Arun District Council
Arun Civic Centre
Maltravers Road
Littlehampton
West Sussex BN17 5LF
Planning & Building Control General Enquiries
Tel: (01903) 737756 Fax: (01903) 730442
Dx: 57406 Littlehampton
Minicom: 01903 732765
e-mail: planning@arun.gov.uk
website: www.arun.gov.uk/planning

Application No: R/62/20/HH
Site Address: Smugglers 4 Botany Close Rustington BN16 2BH
Description of works: Erection of detached garage.

Thank you for your internet representation made on 6th May 2020 which has been recorded as an objection with the comments as follows:

Proposed Elevations
1:100

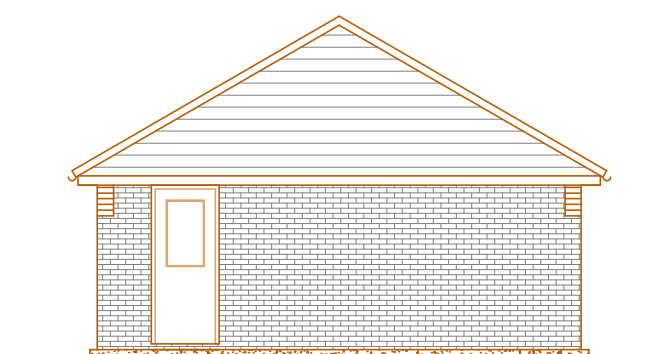
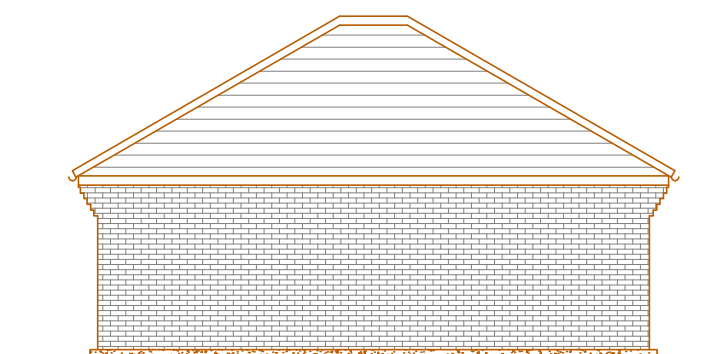
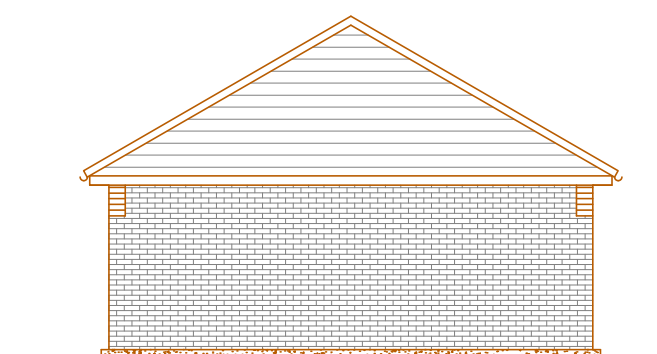
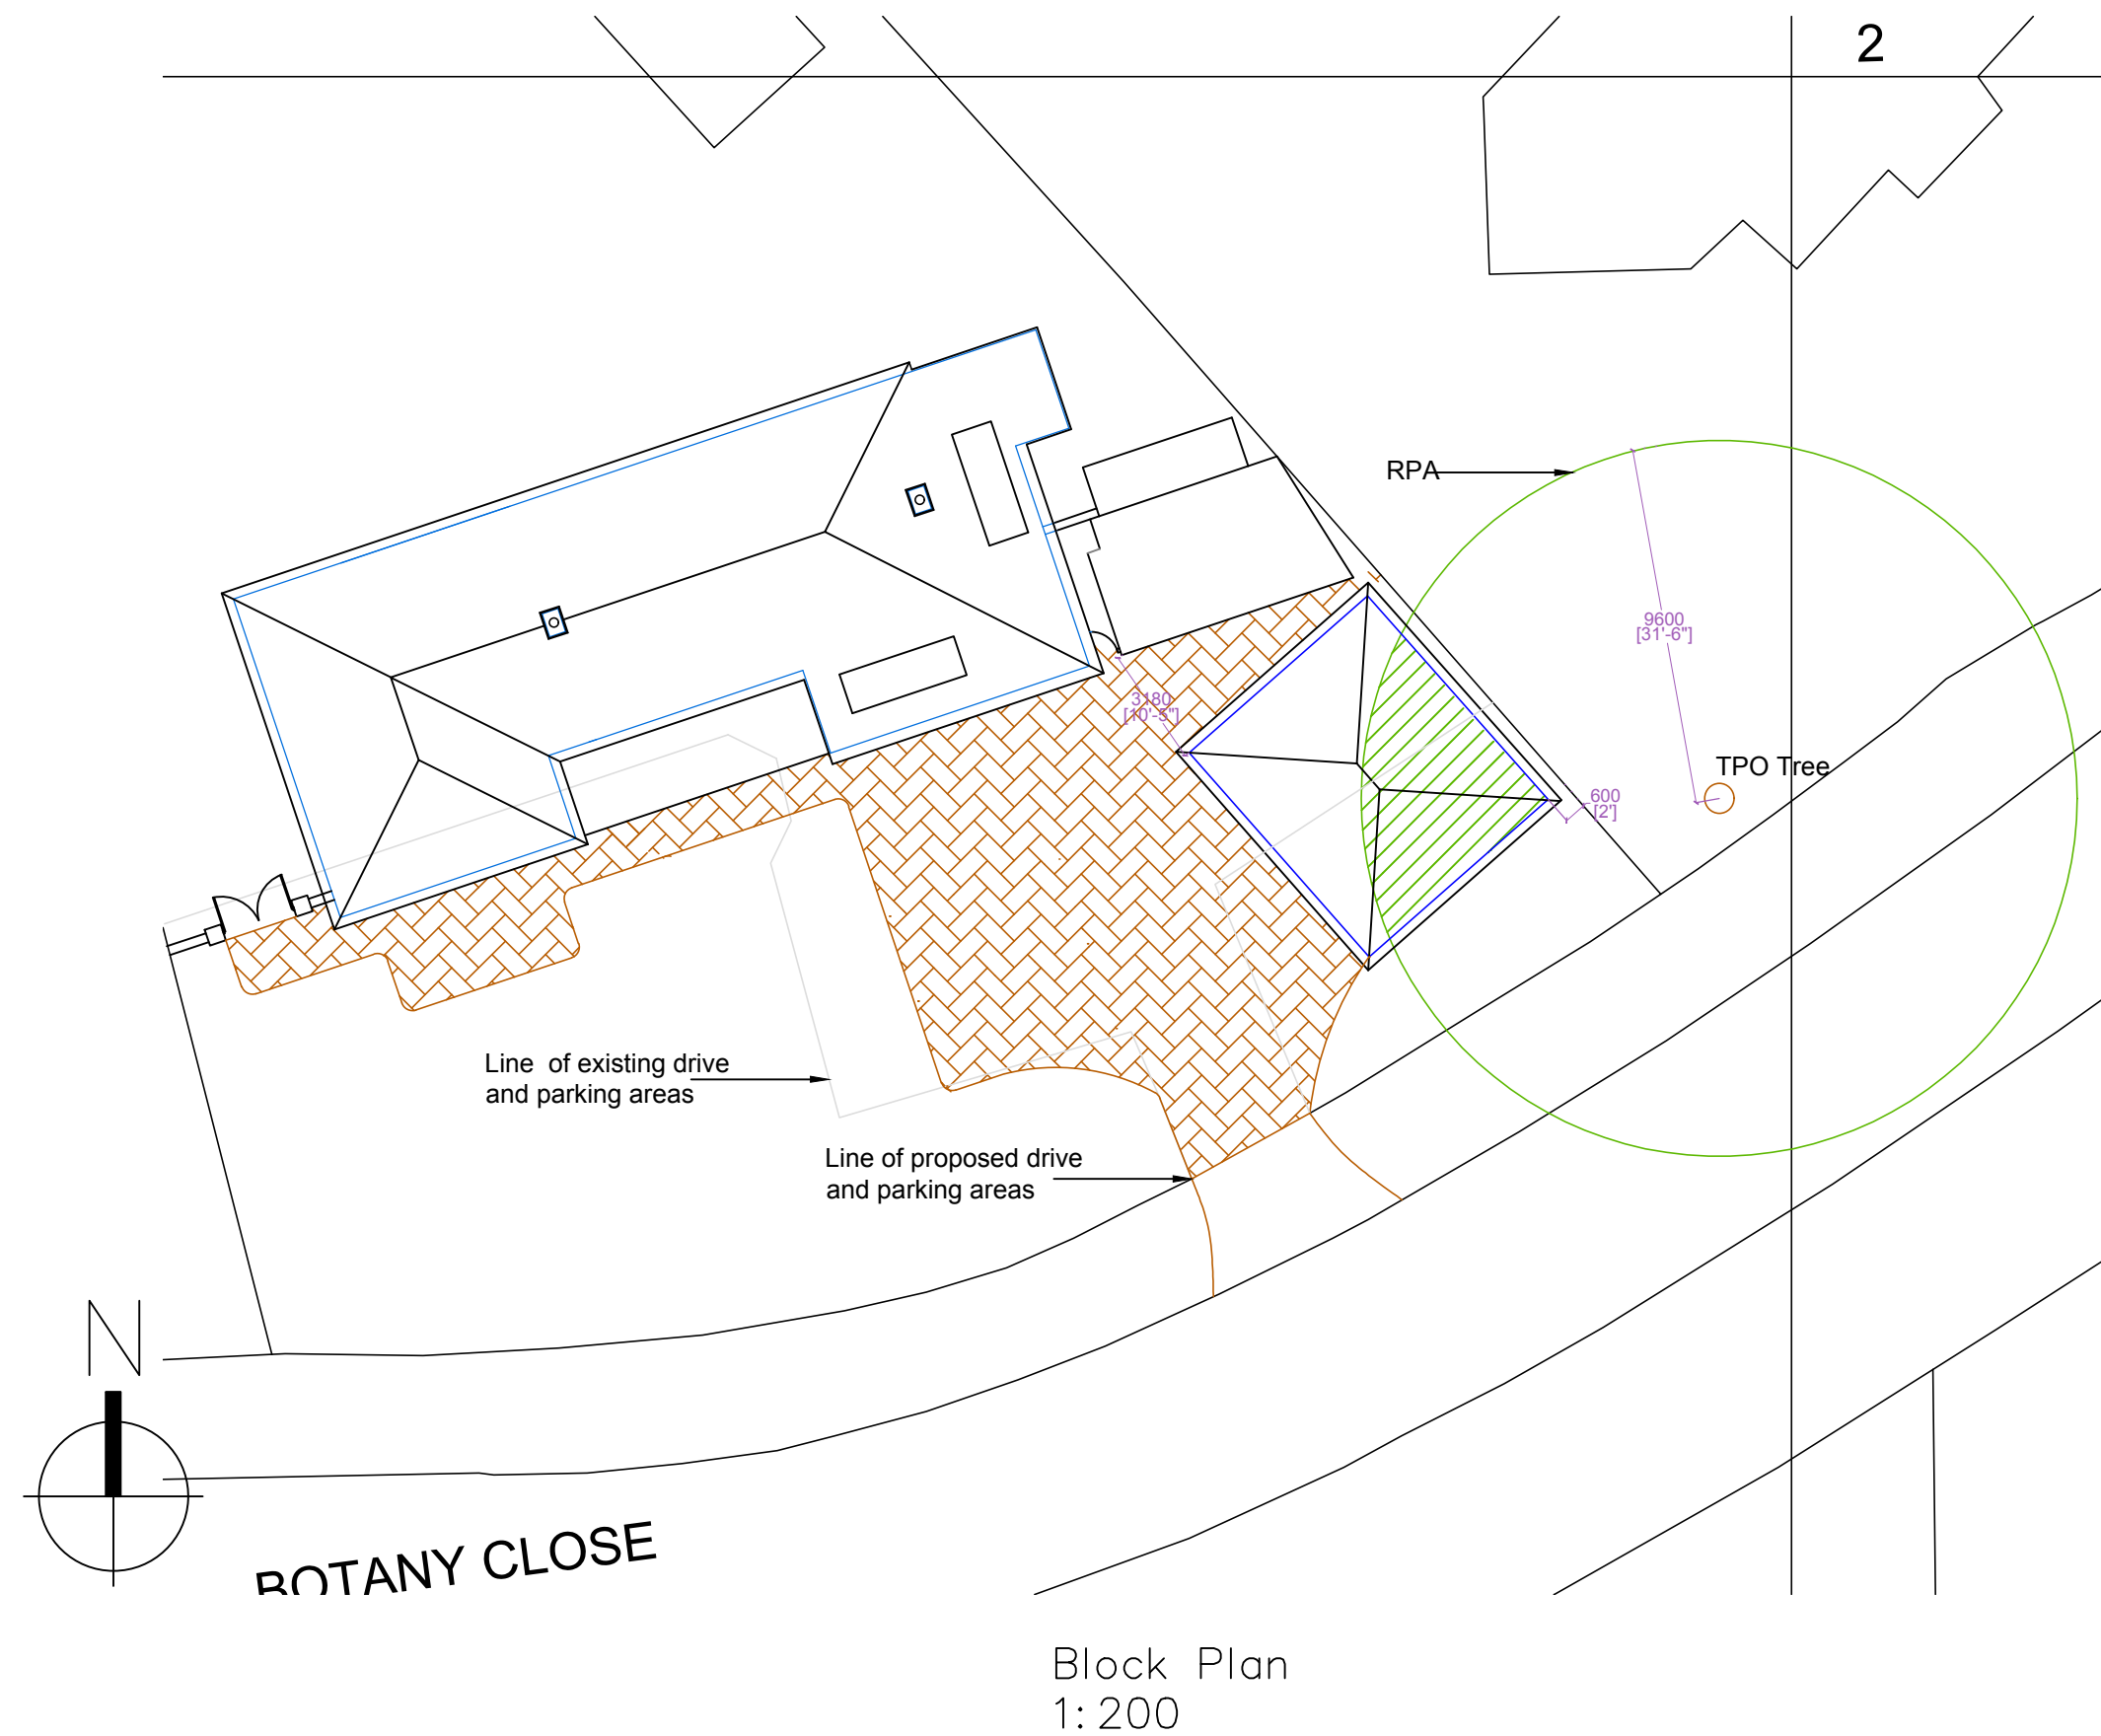
We have looked at the plans for the double garage and are worried about this structure even more so. The height of the pitched roof will be much higher than our fence and our understanding is that it will be right along our fence.

This area of our garden is one that is used practically every day. Our three children have a playhouse there, two swings, a slide and a trampoline. If the garage is built, it will feel imposing and overshadowing, as it will be looming over the fence.

The planned garage is also not only in front of the line of the neighbour's house, but also in front of the line of our house, which surprised us, again changing the street scene and with the way it is presented on the boundary, it almost feels that we should need planning permission ourselves!

In summary, we feel that the visual impact and height of this structure, along with its proximity to our border will spoil our views and feel of our house as it is.
